East Anglia One North (EA1N) and East Anglia Two (EA2) Offshore Wind Farms

Deadline 3 - 15 December 2020

Comments of Suffolk County Council as Local Highways Authority

Suffolk County Council Response to East Anglia One North and East Anglia Two Offshore Windfarms Clarification Note: Sizewell Projects Cumulative Impact Assessment (Traffic and Transport)

Diagram of Traffic Movements Assigned to the Highway Network

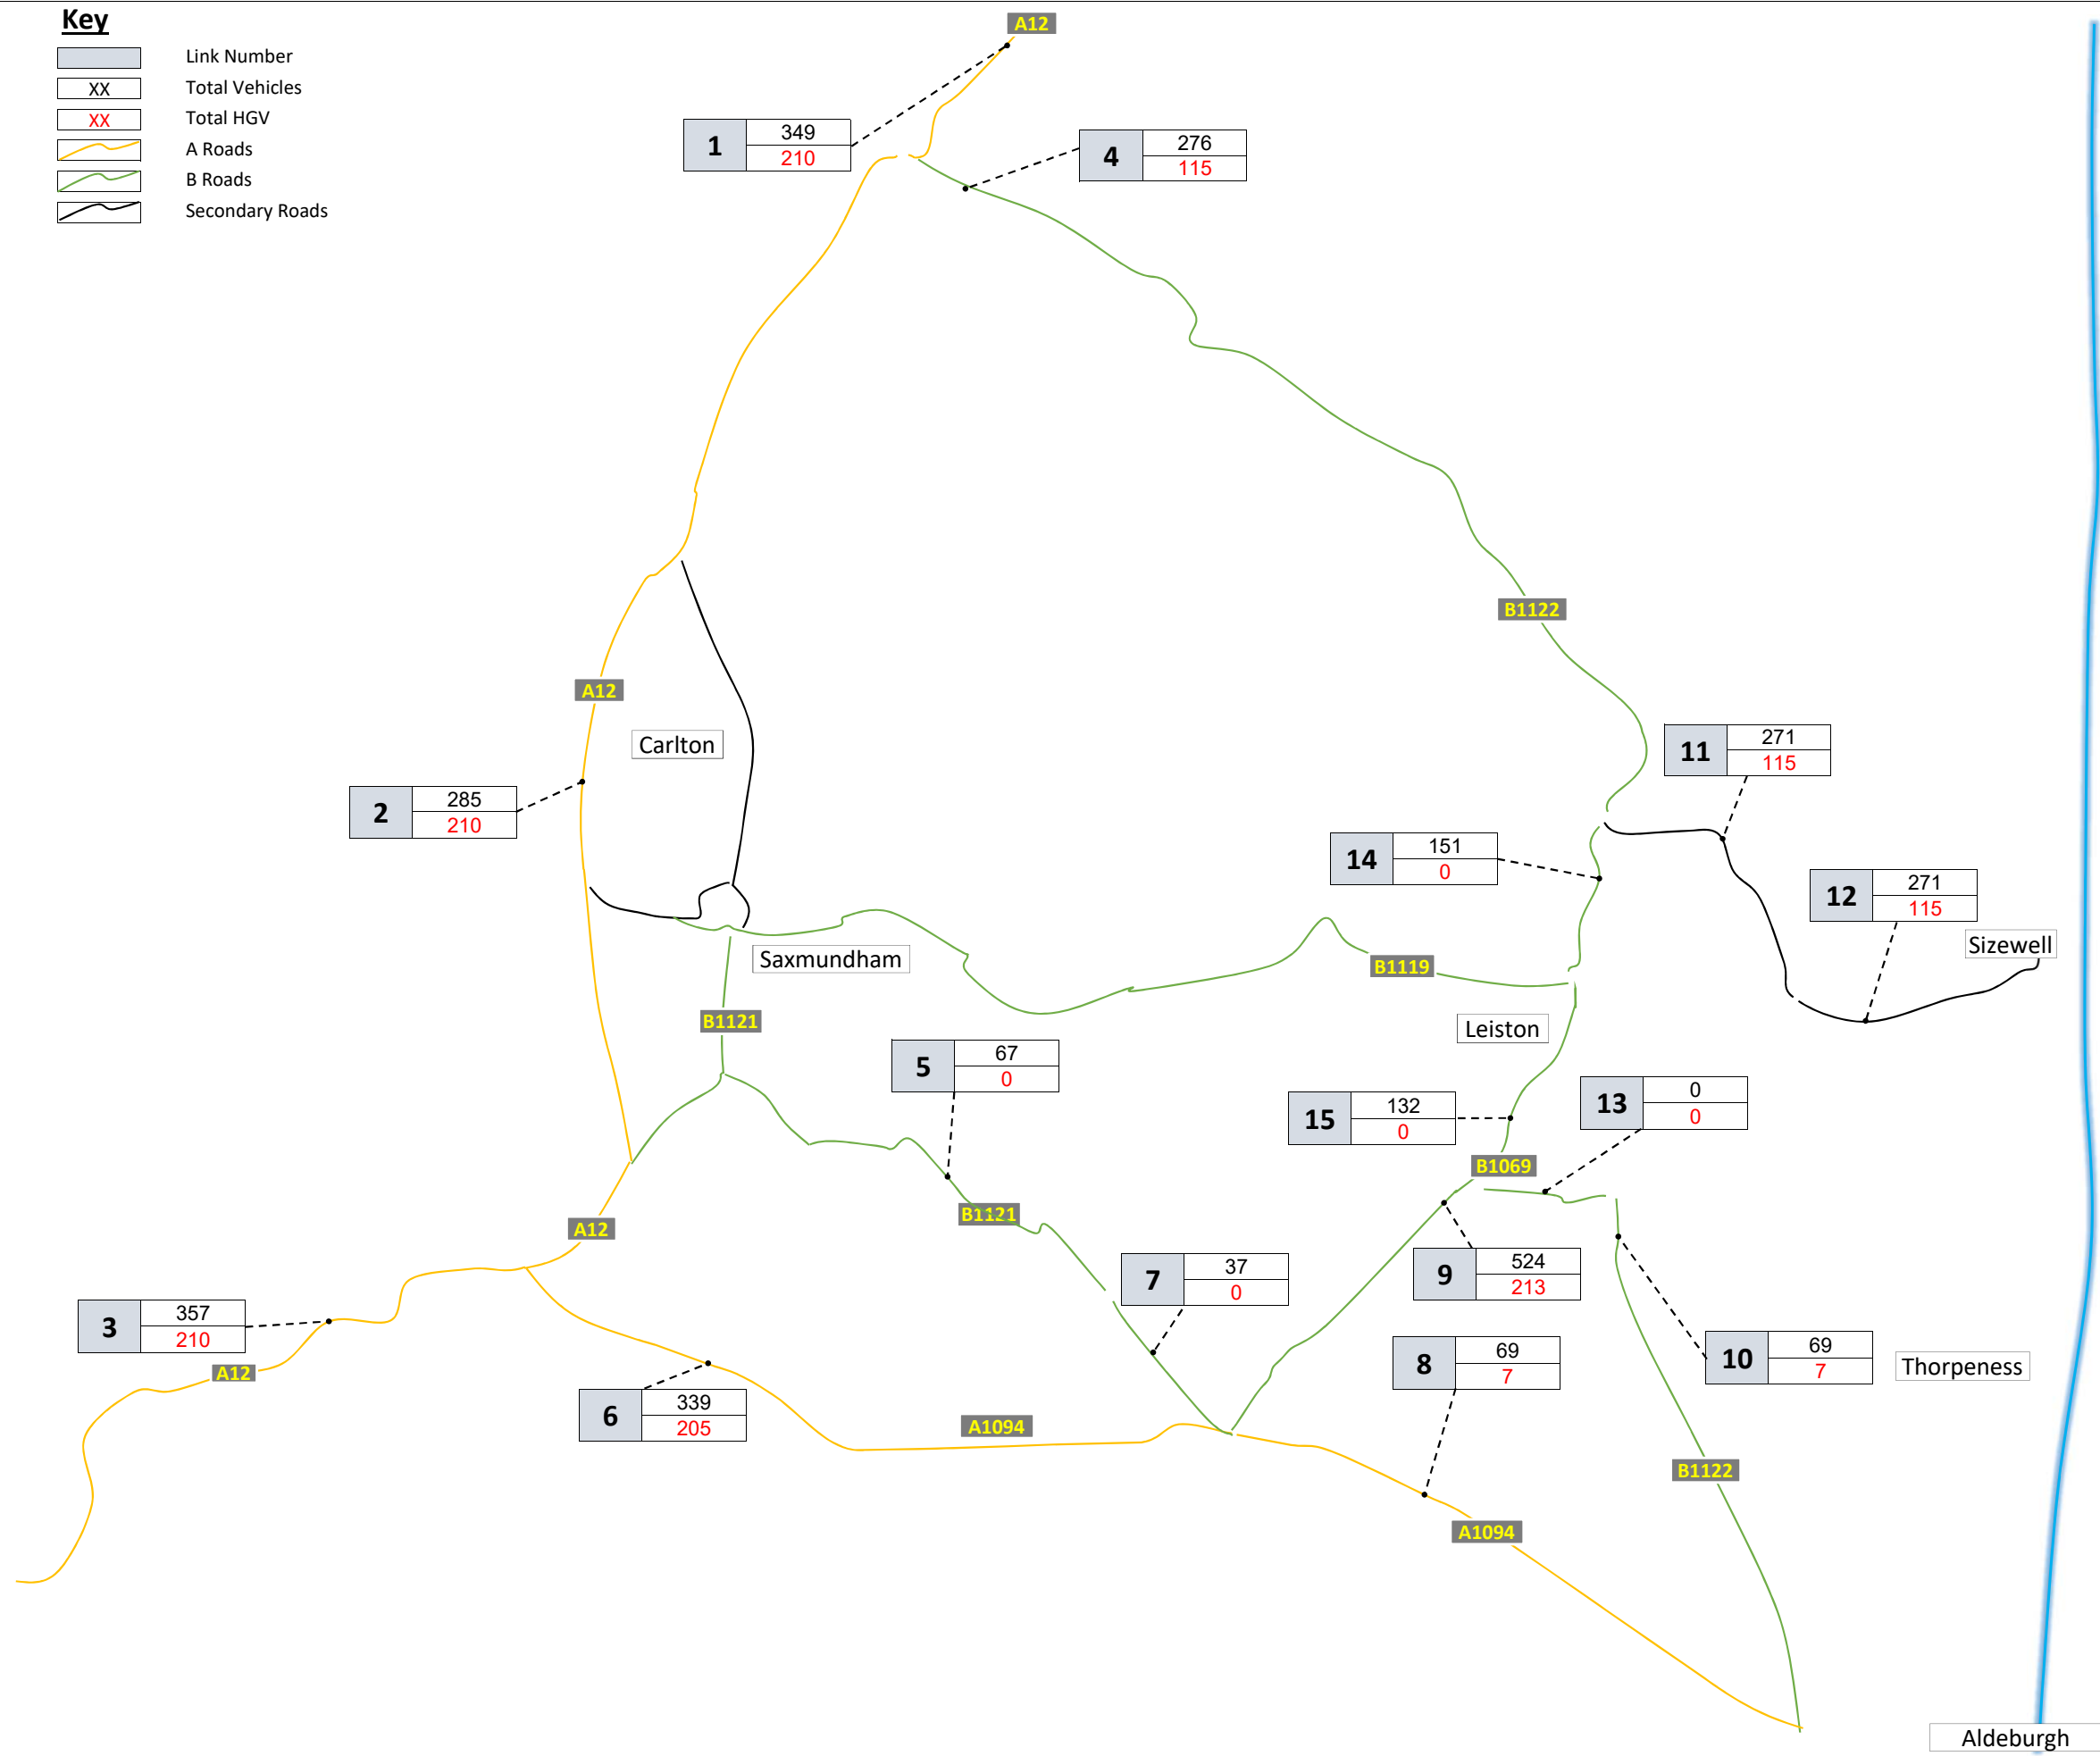
- 5.6. It is noteworthy that Link 9 is the only link at 'Table 2.4 Pedestrian Amenity (Scenario A)' where a potentially significant impact has not been identified. It is understood that this is because the receptor has a low sensitivity, but the Magnitude of Effect of the impact is 'Medium'. As no criteria exists to determine where the differentiation is between a 'Medium' and 'High' Magnitude of Effect in 'Pedestrian Amenity' this is a judgement made by the Applicants whereby a 135% change in HGV flow is not considered to be 'High' Magnitude of Effect, which would result in a potentially significant effect. Justification of this reasoning is requested by the Councils.

- 5.7. There is a similar issue at 'Table 2.5 Pedestrian Amenity (Scenario B)', where Links 9 and 12 also have Magnitude of Impacts determined to be 'Medium' based on 131% and 166% changes in HGV numbers in Scenario B, as to how you define a High Magnitude of Effect, which would change the potential significance of the impact. Justification of this reasoning is requested by the Councils.

- 5.11. At Paragraph 57 of the CIA the Applicant identifies a potential moderate adverse impact at Link 12 (Sizewell Gap), but that due to the proposed speed limit reduction associated with Sizewell C and that it is implicit that the Projects peak demand would not proportionately contribute to a significant adverse impact. This

rationale should be further explained, the Project has a demonstrable impact on flows along this route, representing in the order of 20 to 30% of the cumulative change in total vehicles and HGVs. It is also noteworthy that no assessment is undertaken of the proportional impact during the development peak hour.
